SSD 9536 – Wyong Hospital Redevelopment - Response to Council Comments

Thank you for forwarding Council's email dated 25 July 2019. We have reviewed Council's comments and provide our response below:

DRAWING NUMBER:
C2020

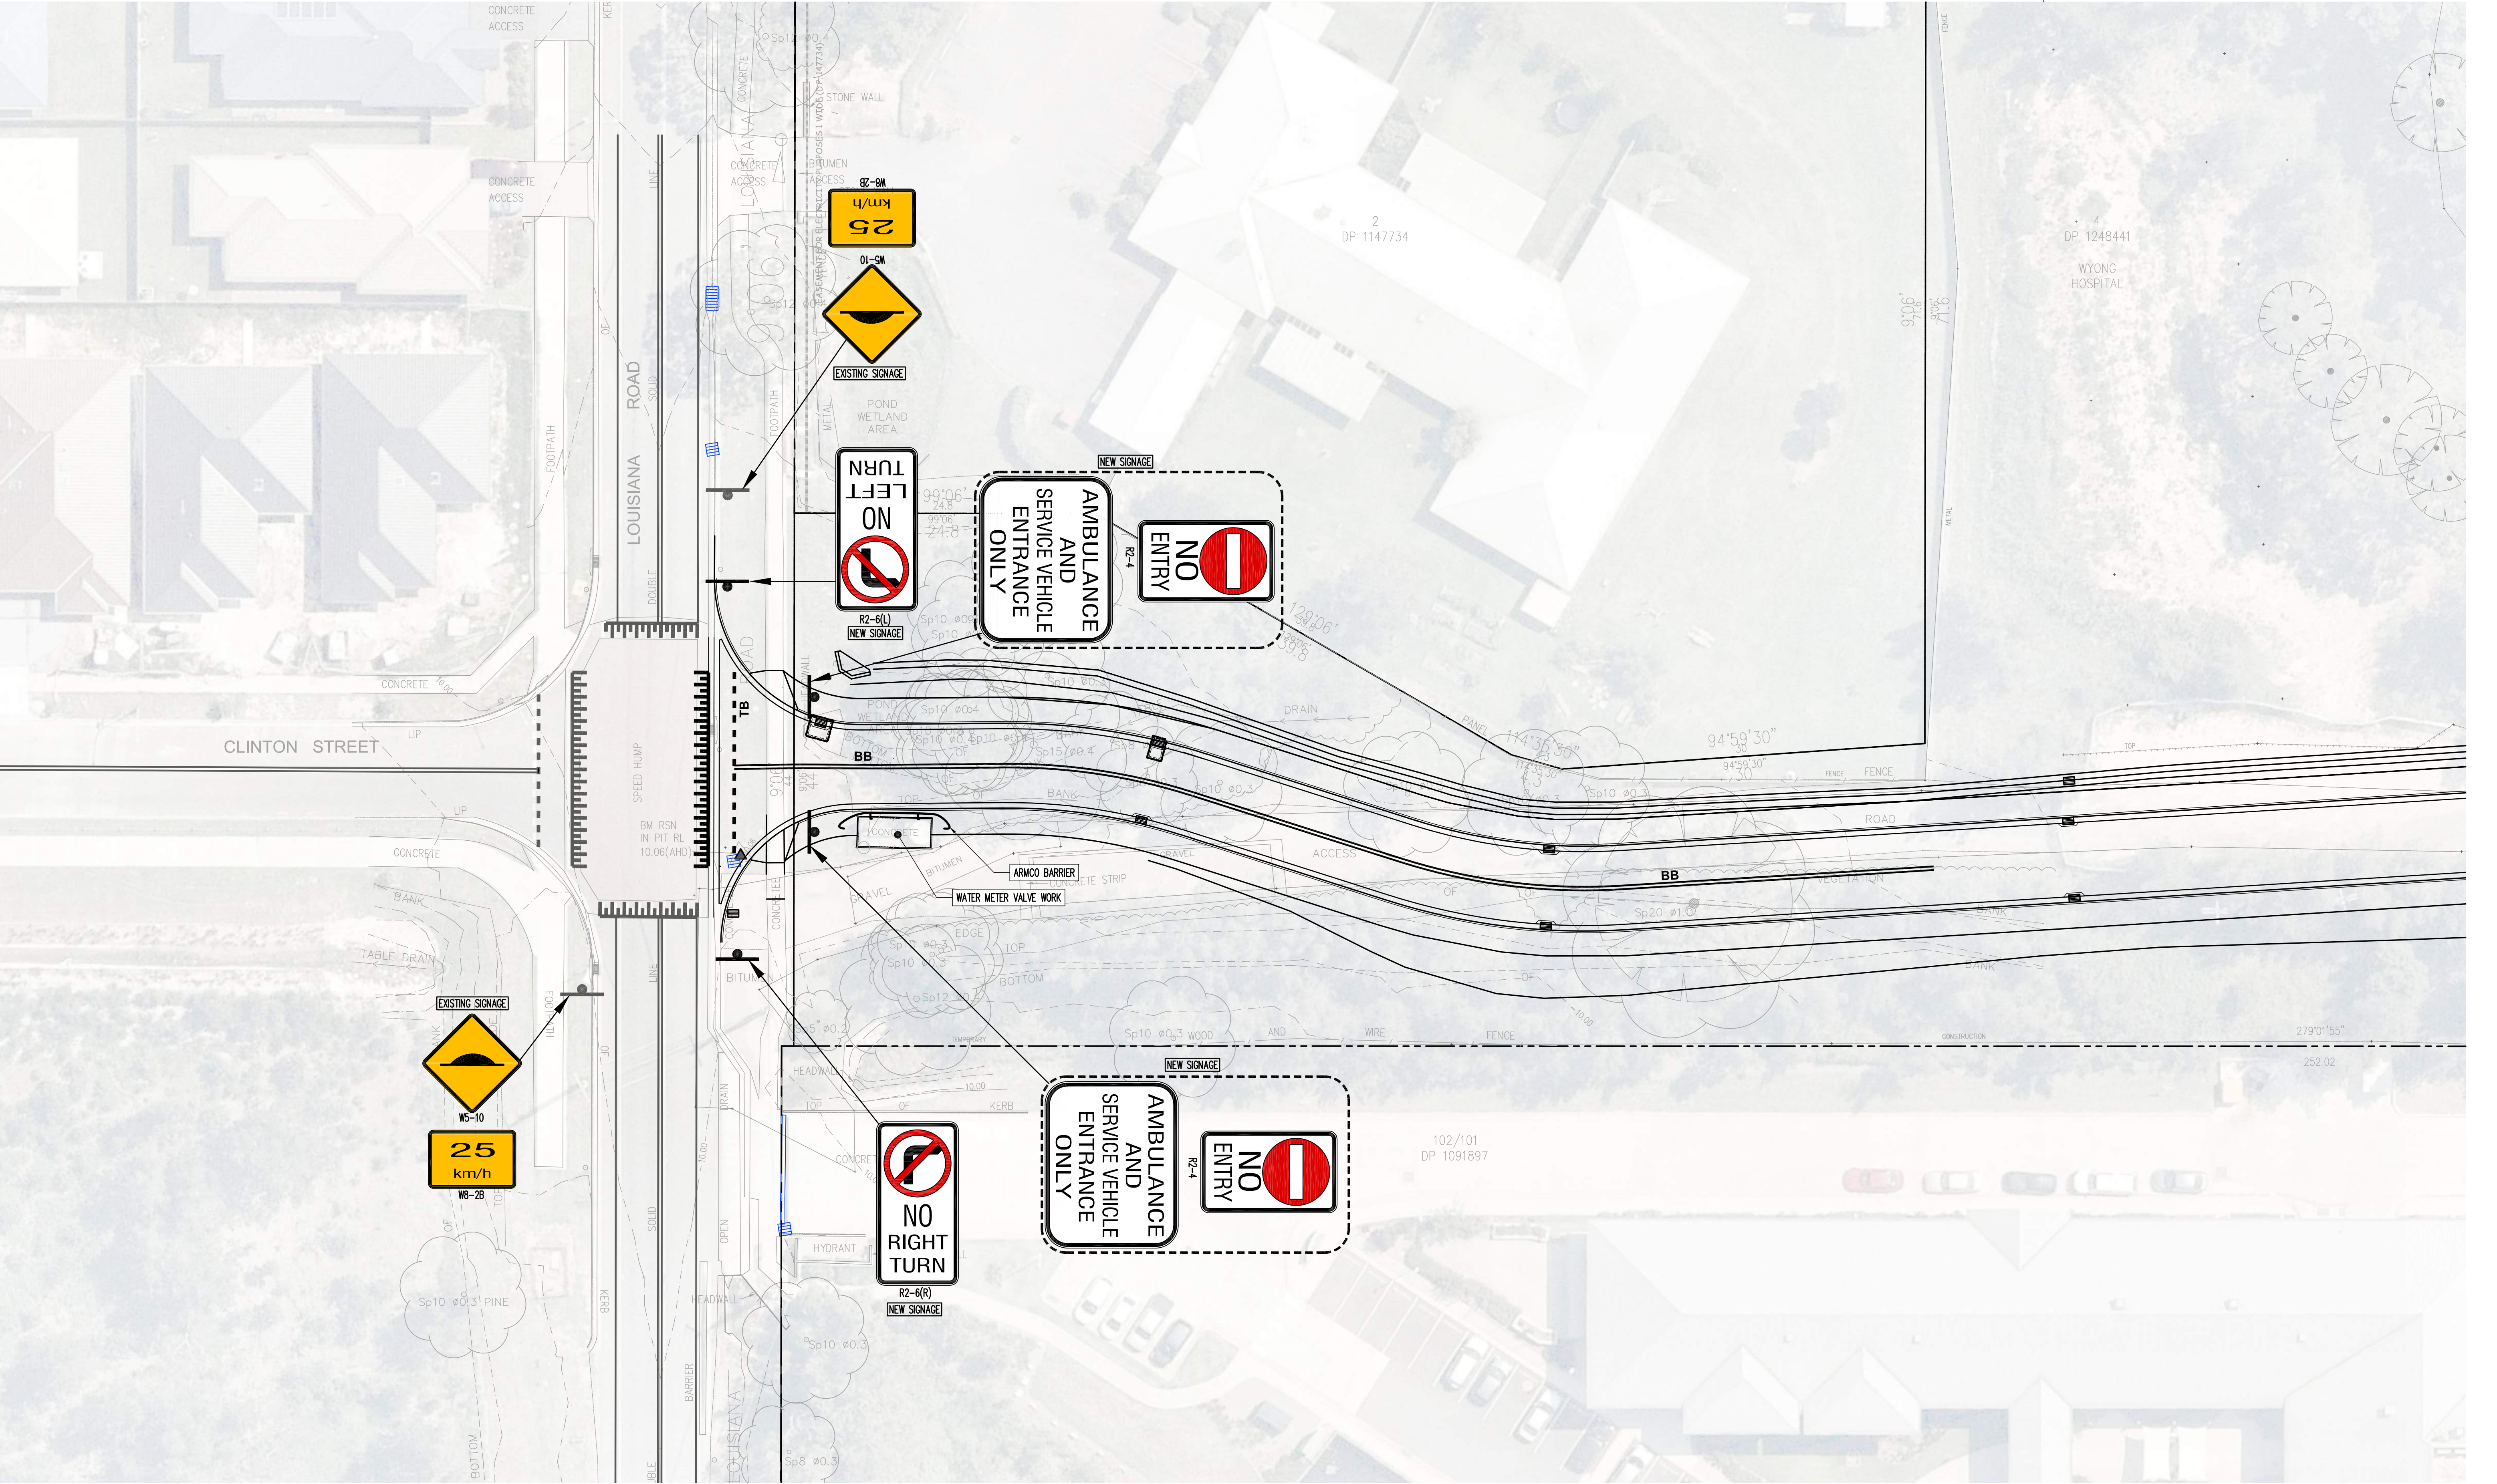
4. Council is waiting for a complete detail design that includes items requested in the email to TTW dated 12 April 2019, particularly points 4 and 8.

- The current design includes road long section including horizontal and vertical geometric elements shown on drawing C2010 (**Attachment B**).
- The extent of dish gutter, verges, footpath, signage and pavement markings are shown on drawings C2001, C2020 and C2030 (**Attachment B**).
